CITY OF ALBUQUERQUE

RE: 8004 Shiprock Ct NW
Grading & Drainage Plan
Engineer's Stamp Date: 6/30/25
Hydrology File: E10D129
Case # HYDR-2025-00229

Based upon the information provided in your submittal received 6/30/2025, the Grading & Drainage Plan **is not approved** for Building Permit. The following comments need to be addressed for approval of the above referenced project.

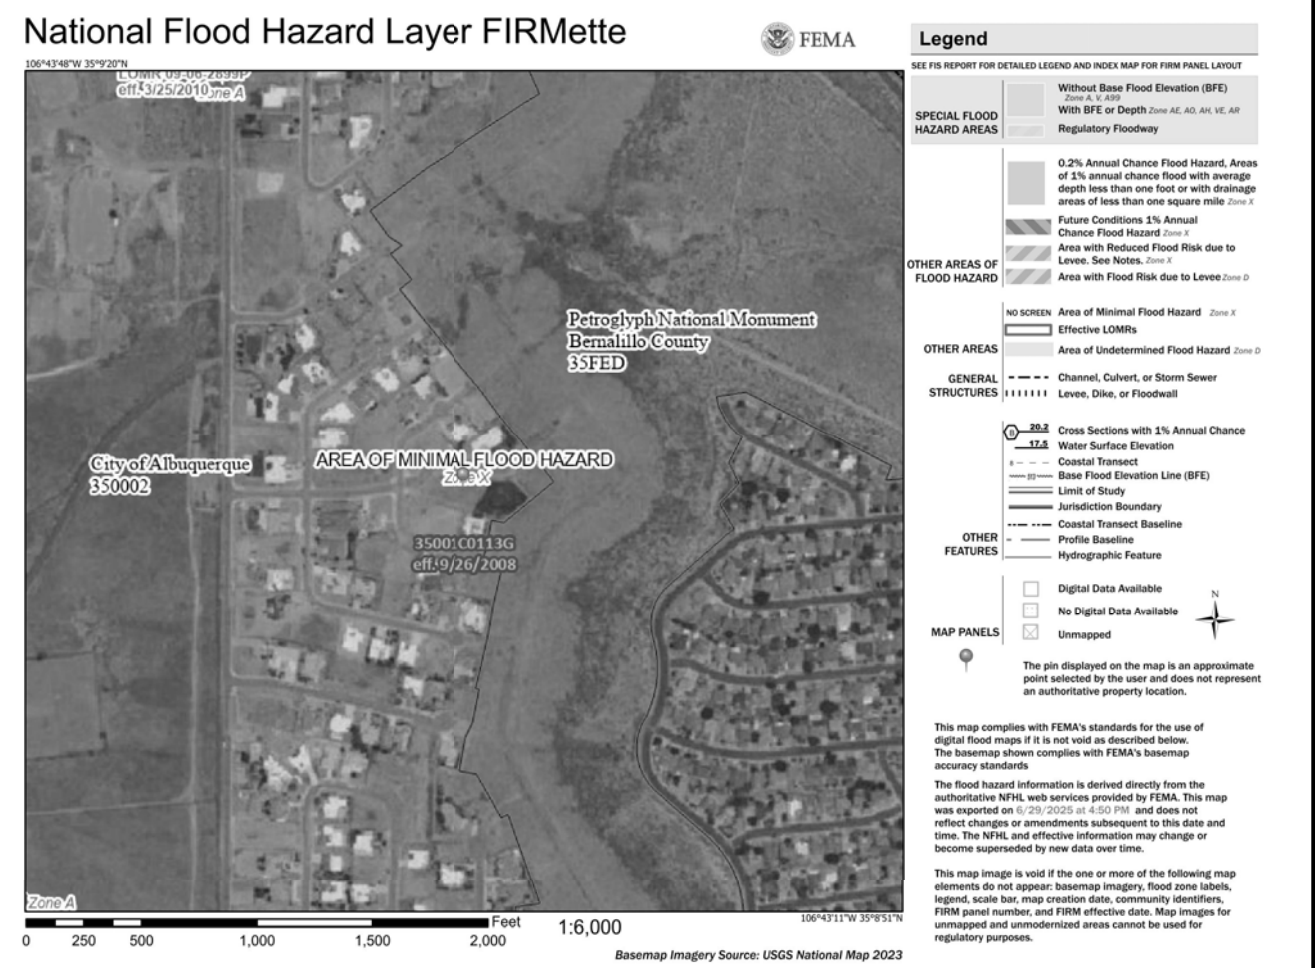
1. Please provide the FIRM Map and floodplain note with effective date.
2. The FF is lower than the FP. Please correct.
